Project #: 100871dp Application #: 11DRB-70212
Project Name: Del Norte Plaza
Agent: Modulus Architects Inc. Phone #:

**CITY OF ALBUQUERQUE
PLANNING DEPARTMENT
December 7, 2011
DRB Comments**

RE: Tract 4, Del Norte Plaza

Project# 1008766

**PASEO DEL NORTE**  
 (VARIABLE WIDTH R/W - ACCESS CONTROLLED)  
 SITE PLAN FOR SUBDIVISION  
 SCALE: 1"=20'

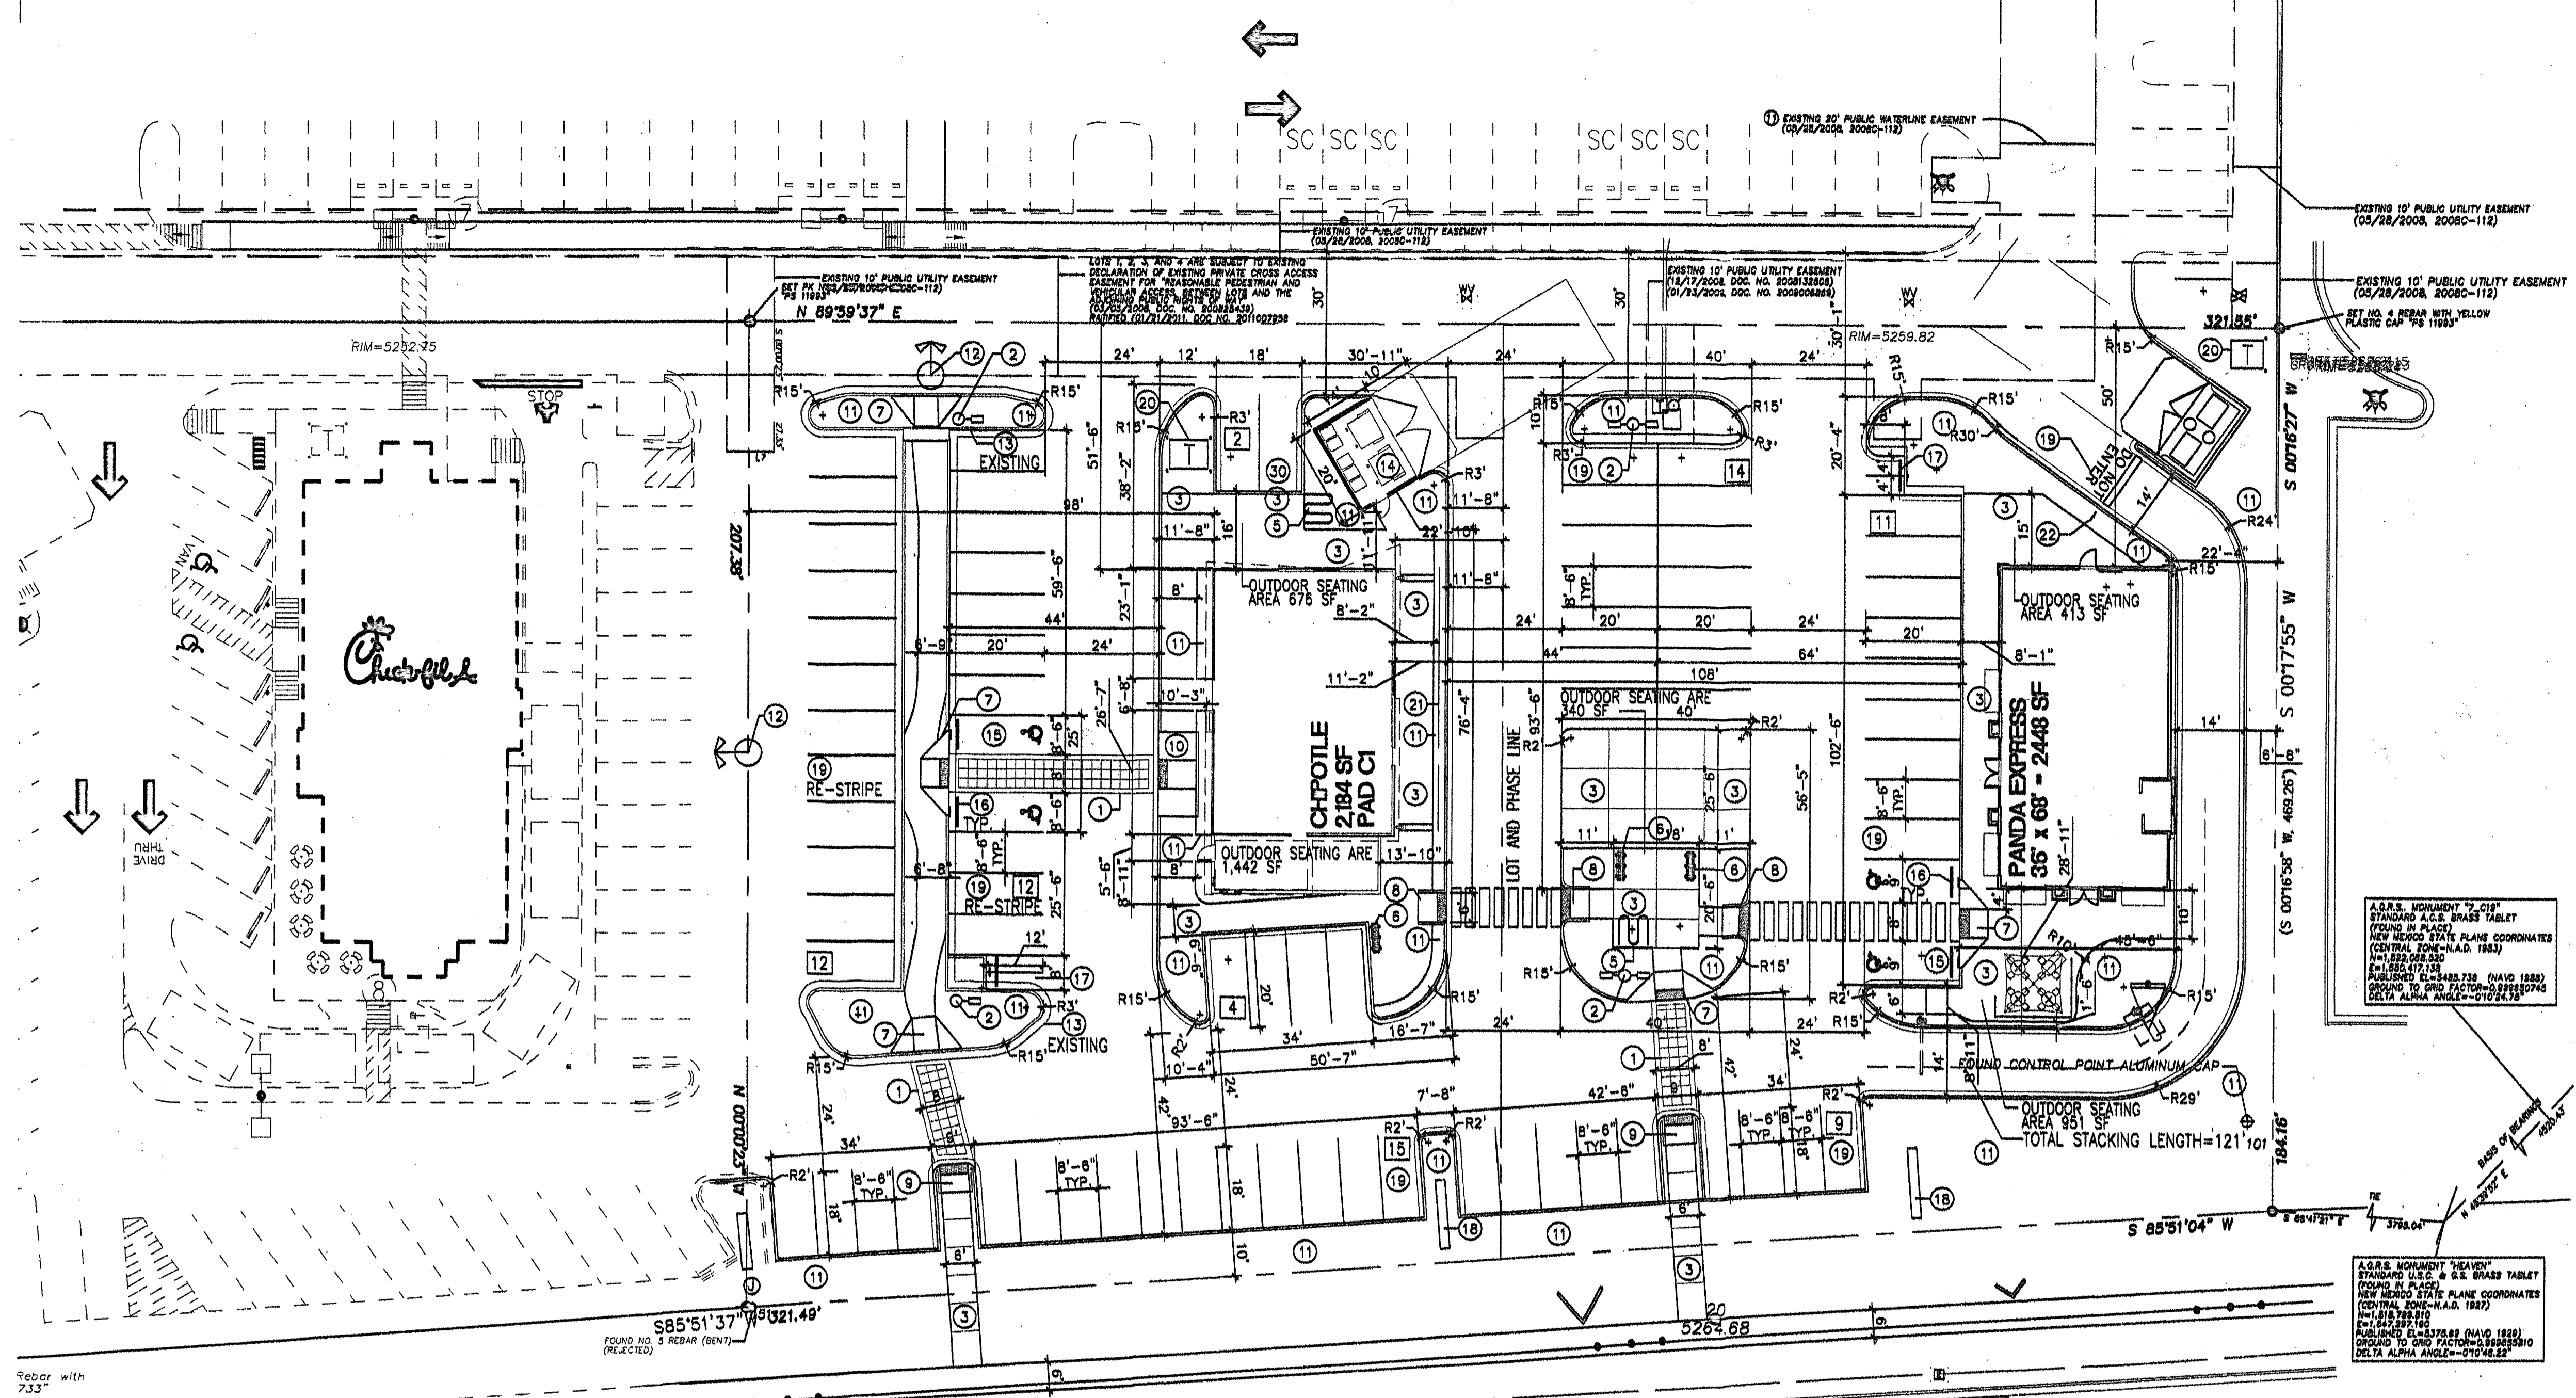
The subdivision line should be more apparent.

Please verify the Total Acreage for each site.

Define all easements and provide recording information.

Proposed amendment conflicts with the approved site plan and the North I-25 Sector Plan (Public Open Space – to be focal point shared by adjoining buildings, and Building Placement – arrange in cluster to define outdoor spaces). Please correct lot size unit from acres to square feet. Clearly indicate proposed lot lines with bold or unique line type.

The access easement referred to on the plan has a recorded date of 03-05-2008; however, the *Common Operation and Reciprocal Easement Agreement for Pacific Paseo* has a recorded date of 05-20-2009. Please revise.

The access easement shown on the site plan does not match the pathway defined as the “Circulation Drive” within the *Common Operation and Reciprocal Easement Agreement for Pacific Paseo* (recorded 05-20-2009).

The Site Plan for Subdivision also has a notation defining the plan as the “Site Plan for Building Permit.” This notation must be removed.

**16 CURBED H.C RAMP**  
Scale: N.T.S.

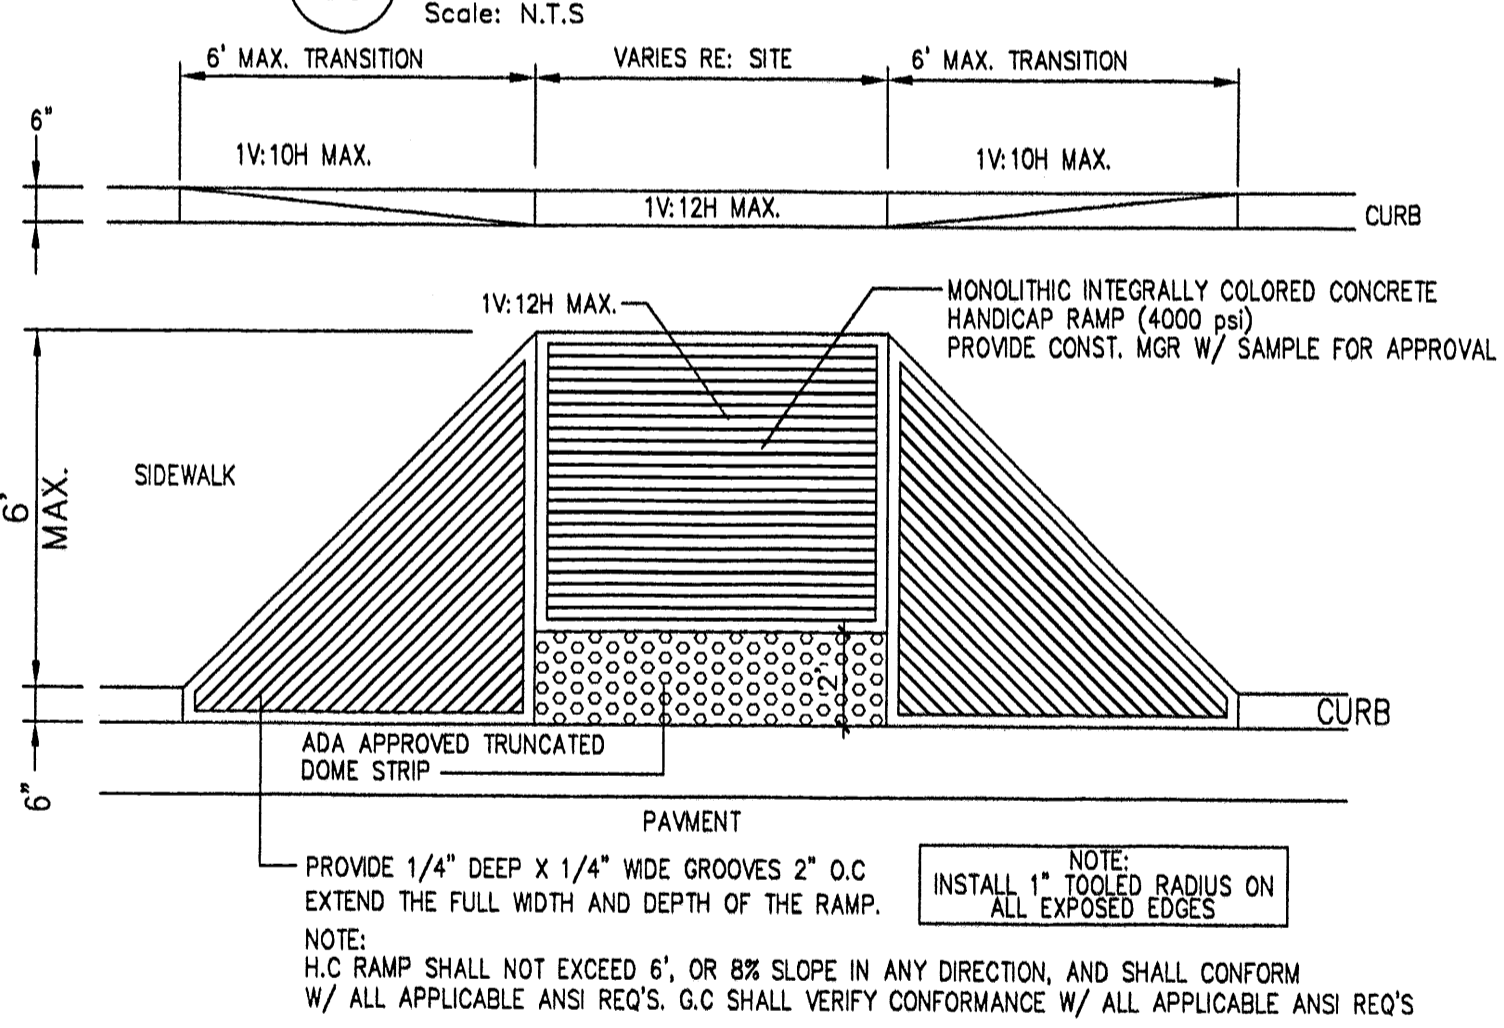
- Detail 16 (Sheet A1.1) does not define the maximum slope of the ramp.
- Detail 12 (Sheet A1.1) does not define the maximum slope of the ramp.

**WEST ELEVATION 1**

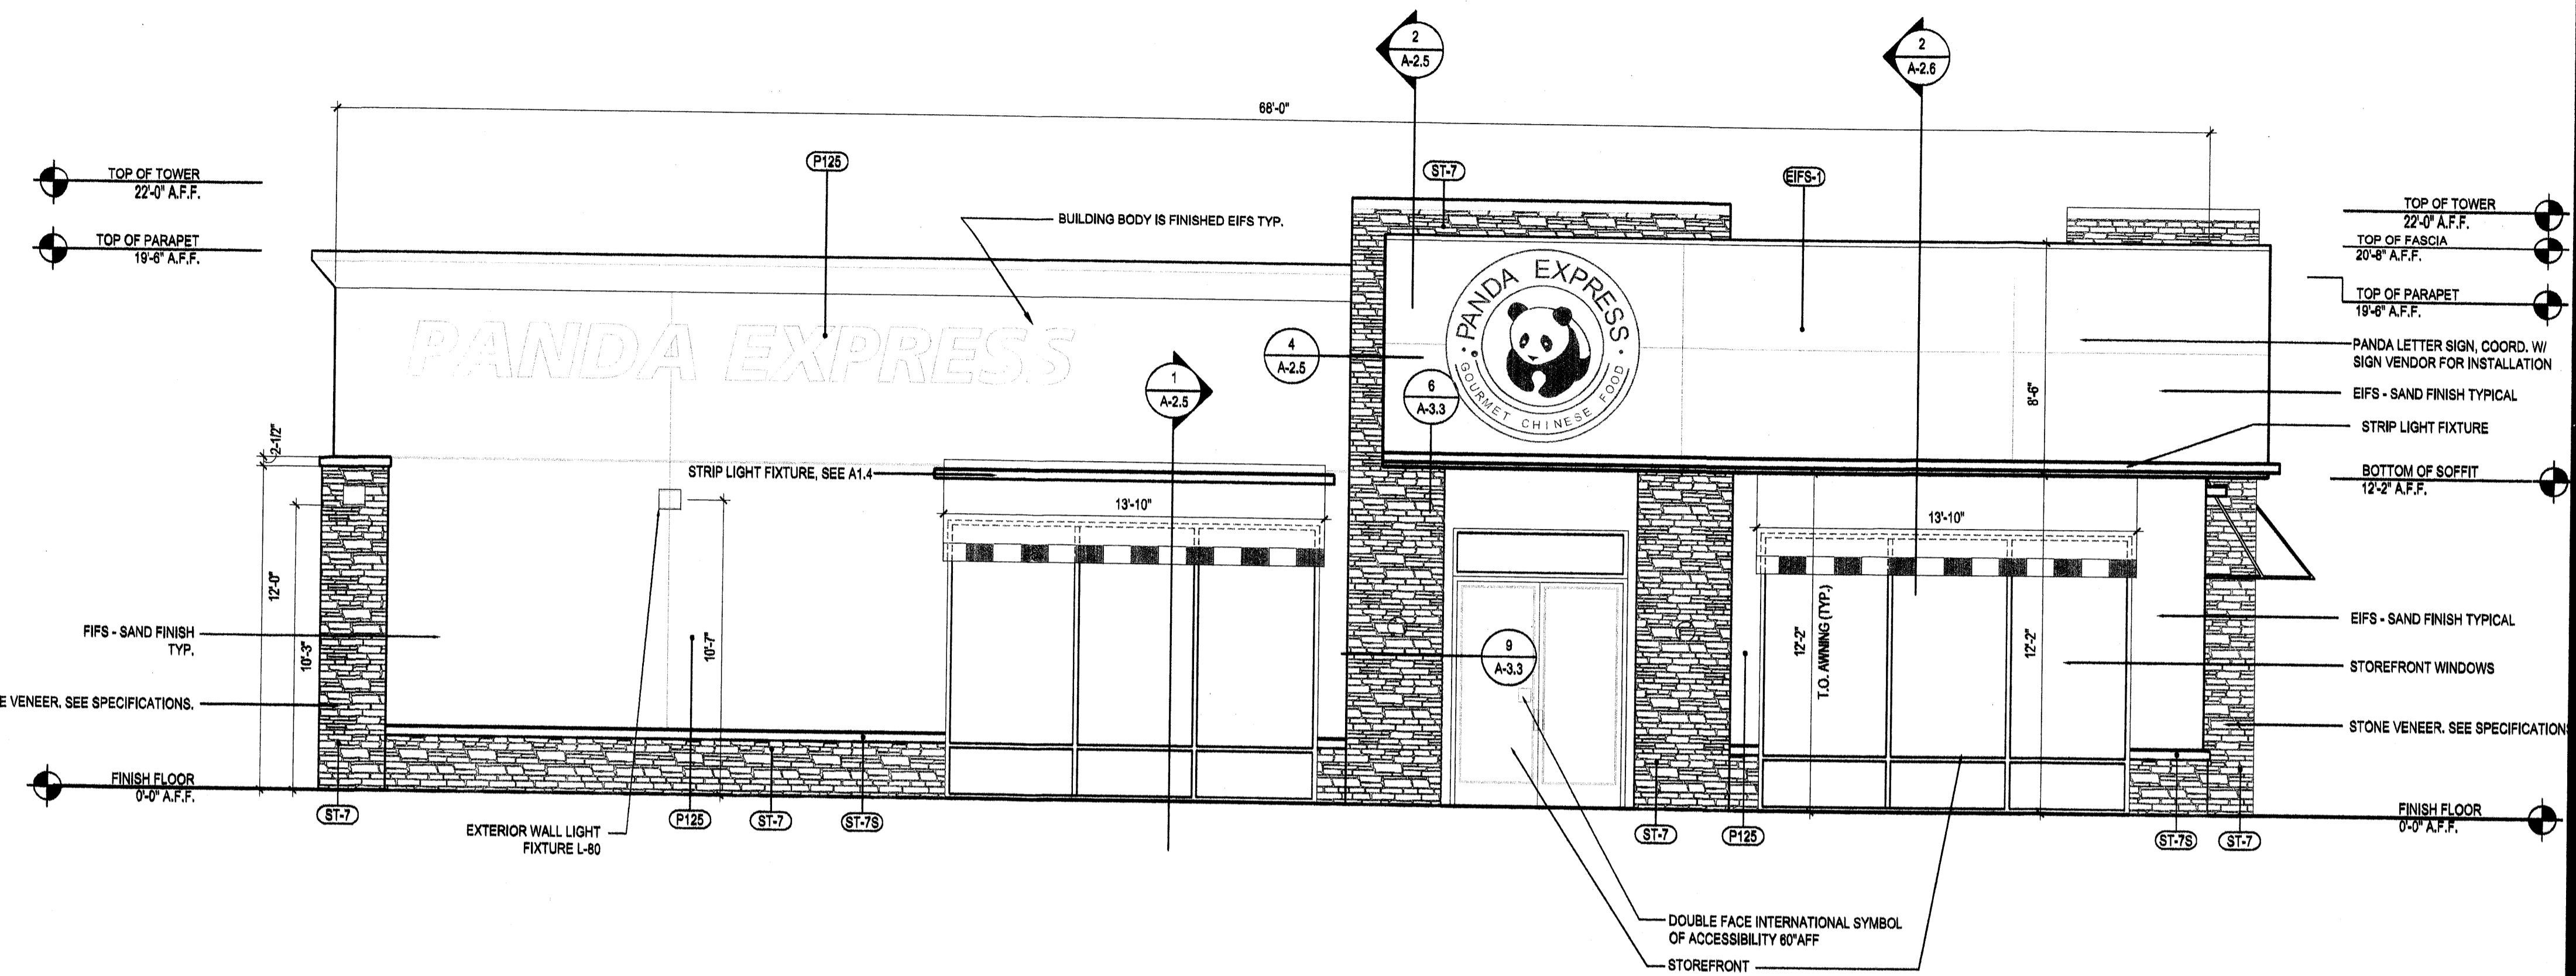
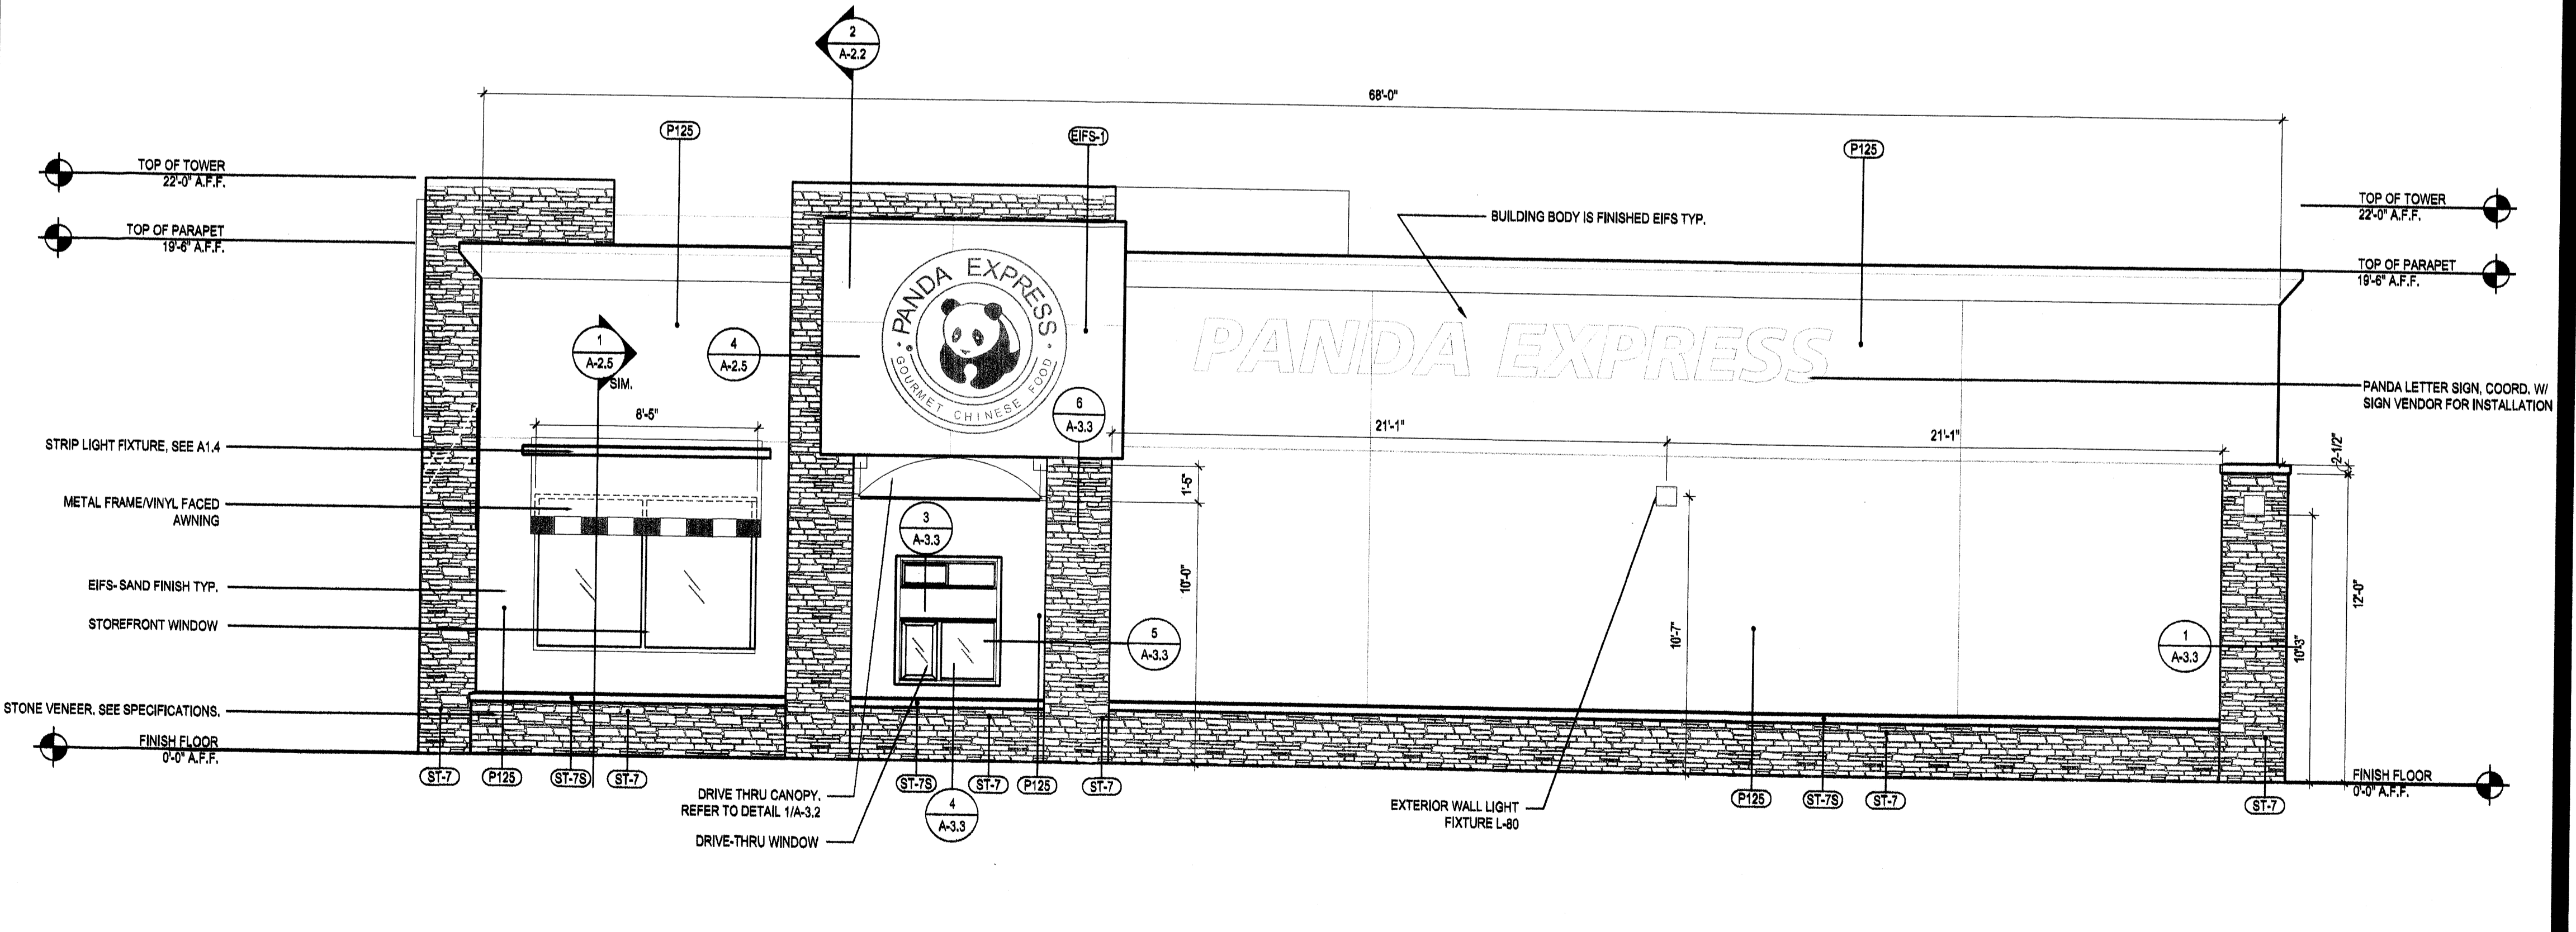
Color elevations are required per the site plan checklist – color photos of the car wash are needed to compare with the proposed Chipotle elevations. Chipotle elevations need to be accurately scaled.

Building design need to present a cohesive visual relationship per the sector plan; refer to brick/stone wainscott with stucco for McDonald's and Chick-fil-A. Building elevations for Chipolte need to note material and color and must be dimensioned; roof mounted equipment must be screened, and only two building mounted signs are permitted. Any building mounted signage for Panda Express must be shown on elevatons.
